landscape design report

Mosman High School
745 Military Road LOT: 1 DP: 1268793
Mosman NSW
March 2021
SSDA ISSUE_ Revision 07
prepared by Black Beetle

Figure 31 Tree Location Plan  
Source: Arboricultural Impact Assessment , Birds Tree Consultancy

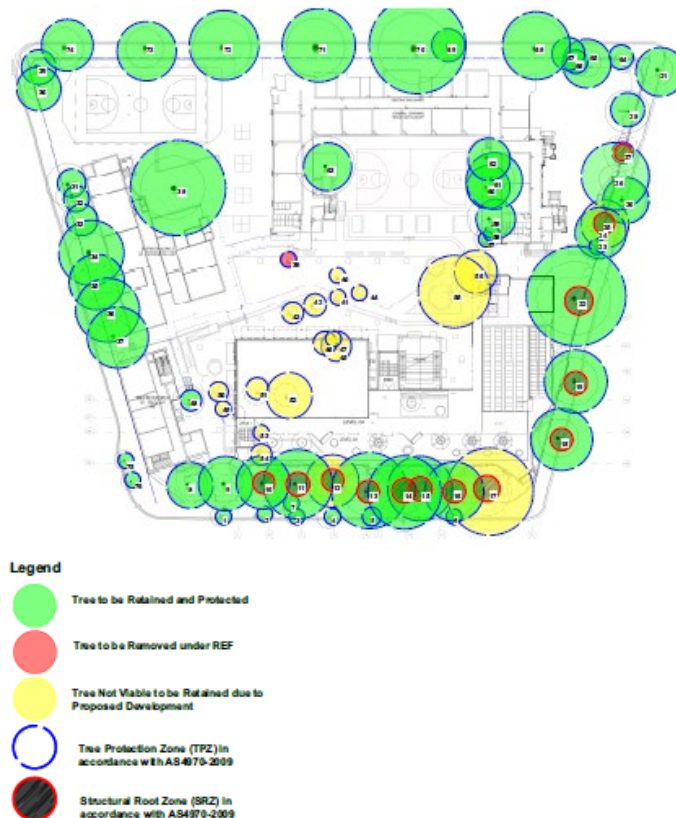
- *Demonstrate how recommendations from the Arboricultural report will be implemented to protect the root zones of the existing trees to be retained (particularly along Military Road). Consideration may need to be given to elevated walkways to minimise and / or avoid excavation.*

The current proposal includes the use of an elevated walkway so that minimal impact on tree roots along the Military Road frontage will be achieved. Along with minimal disturbance to the root systems improving soil conditions will be proposed to enhance the longevity of Screen Planting.

Figure 49 Circulation and Access (noting DDA compliant access)  
Source: Landscape Report, Black Beetle Landscape Architects

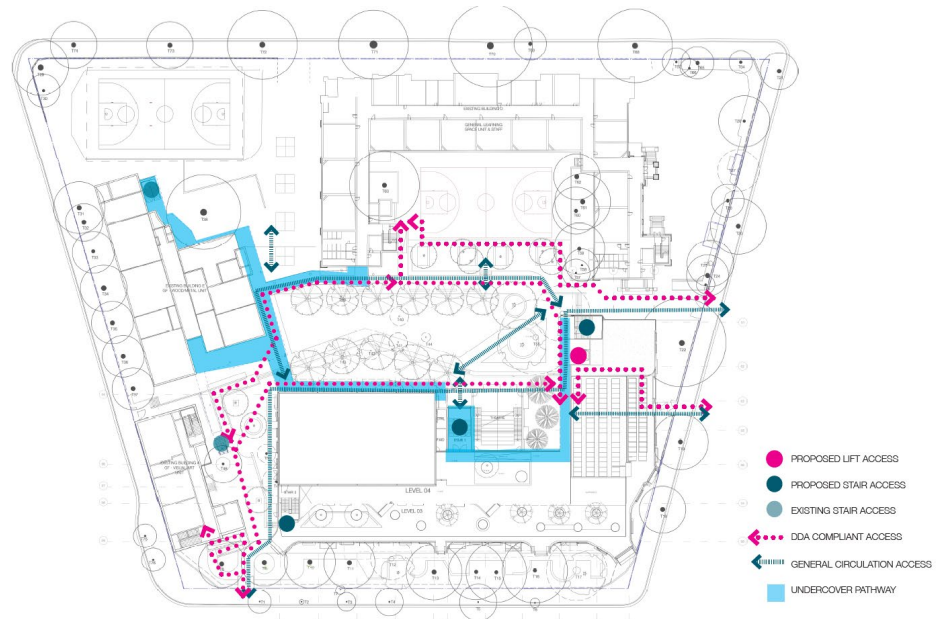
- *Provide drawings with RLs to illustrate that circulation between buildings is safe, weather protected, accessible and inclusive to people with different needs and capabilities. Clarify DDA accessibility between entry points, landscape areas and built form.*

A set of Landscape Concept Plans have been submitted along with this report. A DDA Access and circulation diagram is included in section 1.7 of this submission.
